Our ref: OUT25/10984

Subject: Seniors Housing IRT Woonona Redevelopment, 4-6 Popes Road, Woonona (SSD-73910208) – Environmental Impact Statement (EIS)

# Detailed advice to DPHI Planning & Assessment regarding the Seniors Housing IRT Woonona Redevelopment, 4-6 Popes Road, Woonona (SSD-73910208) – Environmental Impact Statement (EIS)

OPTION 1 - SECANT PILE WALL ONLY

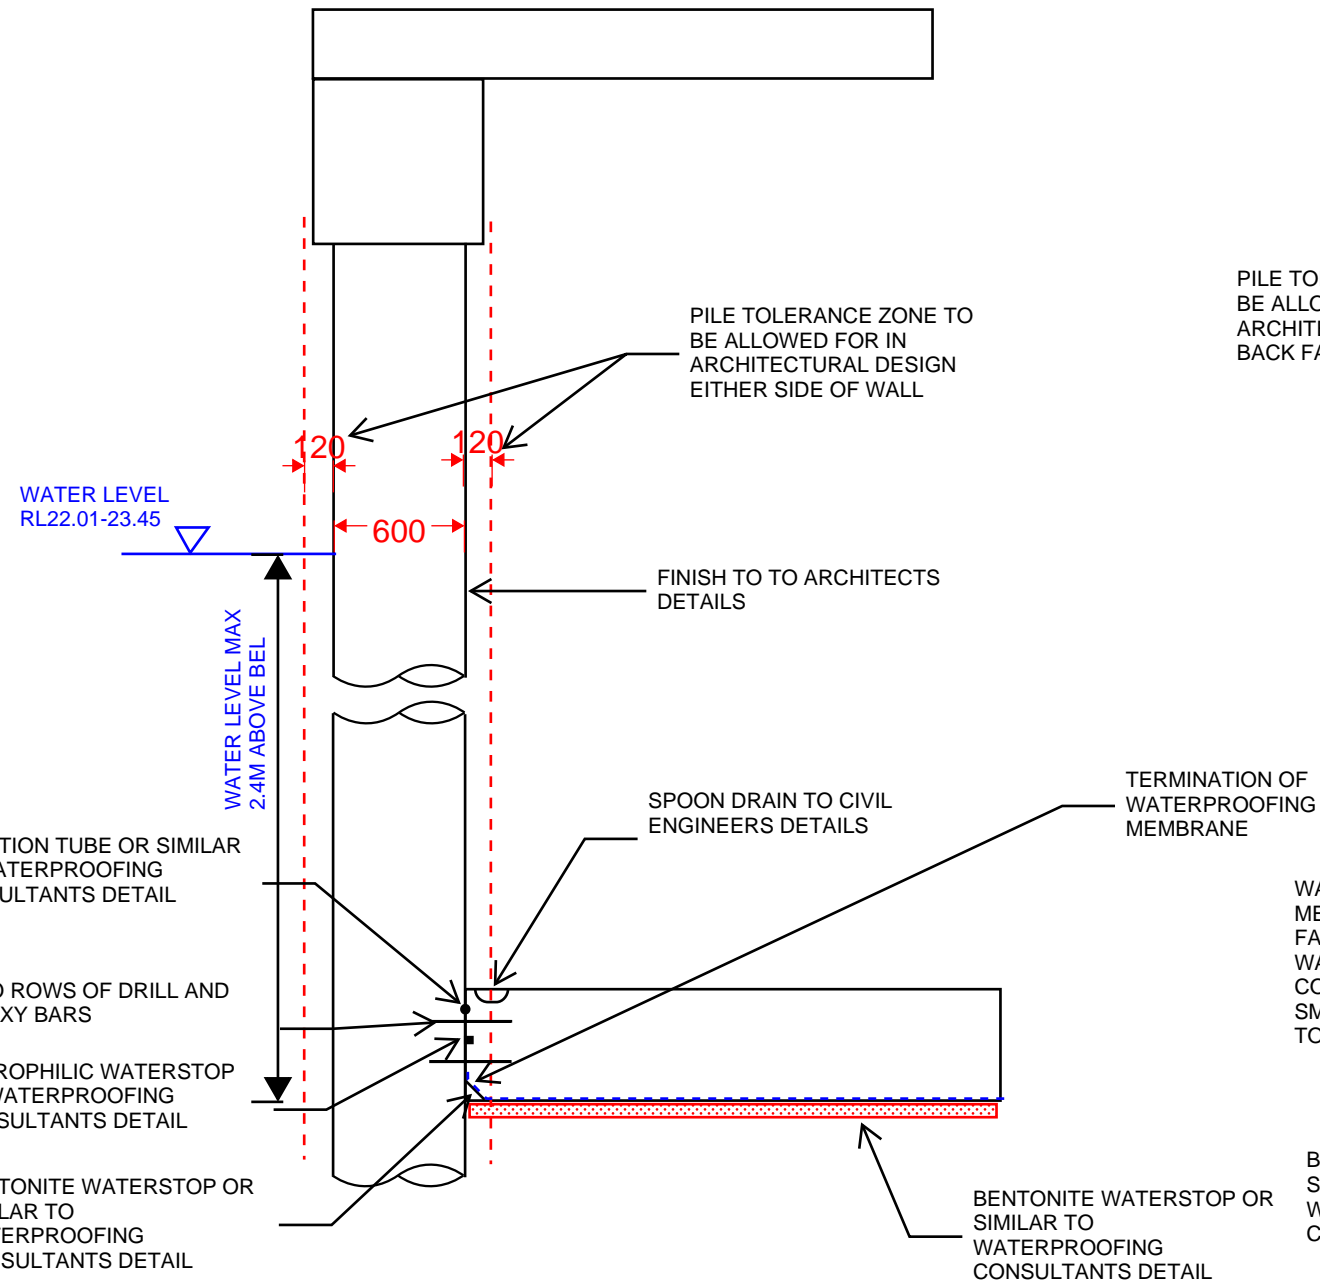
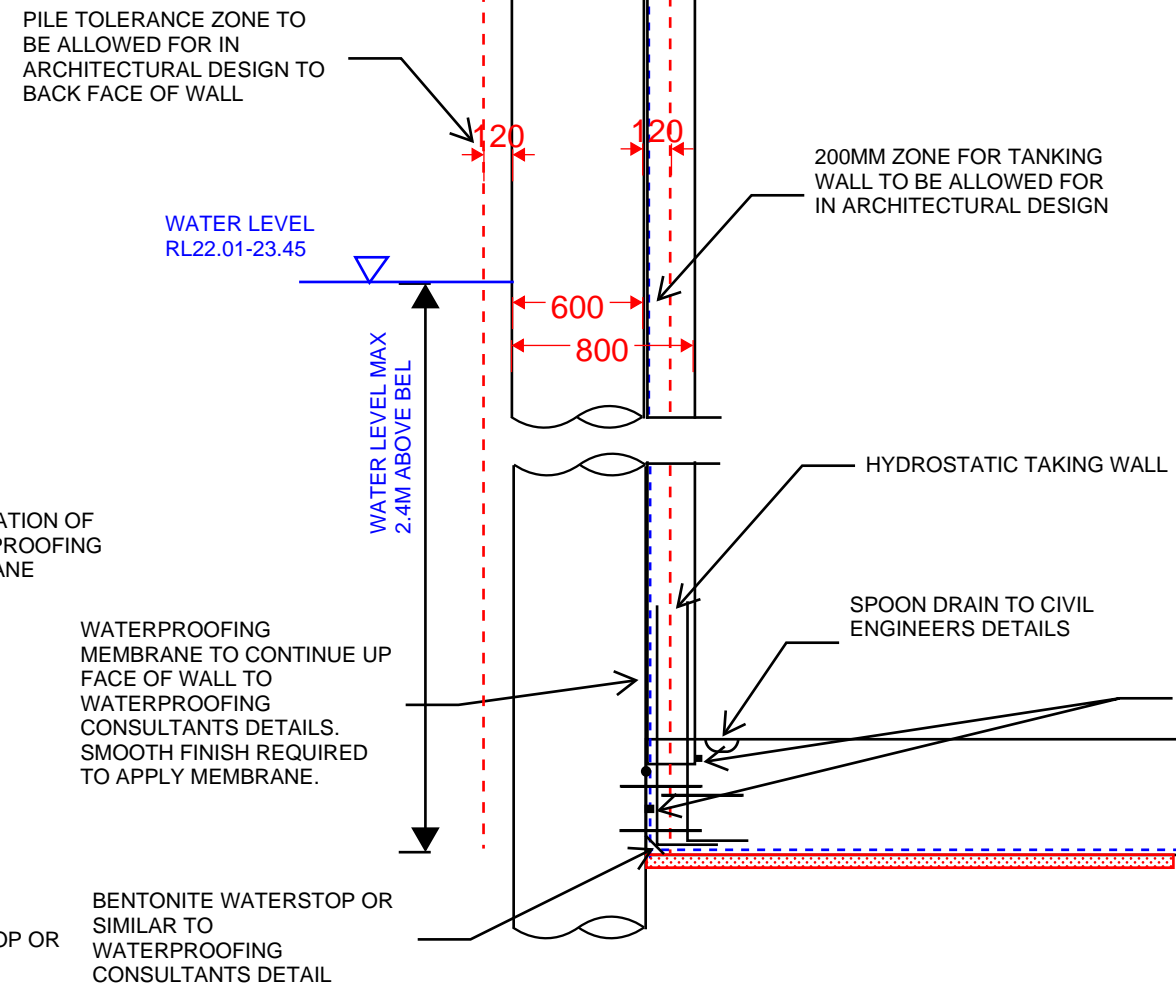
The Department of Planning, Housing and Infrastructure (DPHI) should request clarification from the proponent as to whether the proposed basements will be drained or tanked.

The hydrogeological assessment states that there is uncertainty as to whether the proposed basement will be free draining or tanked and therefore it is not possible to determine the water licensing requirements with certainty.
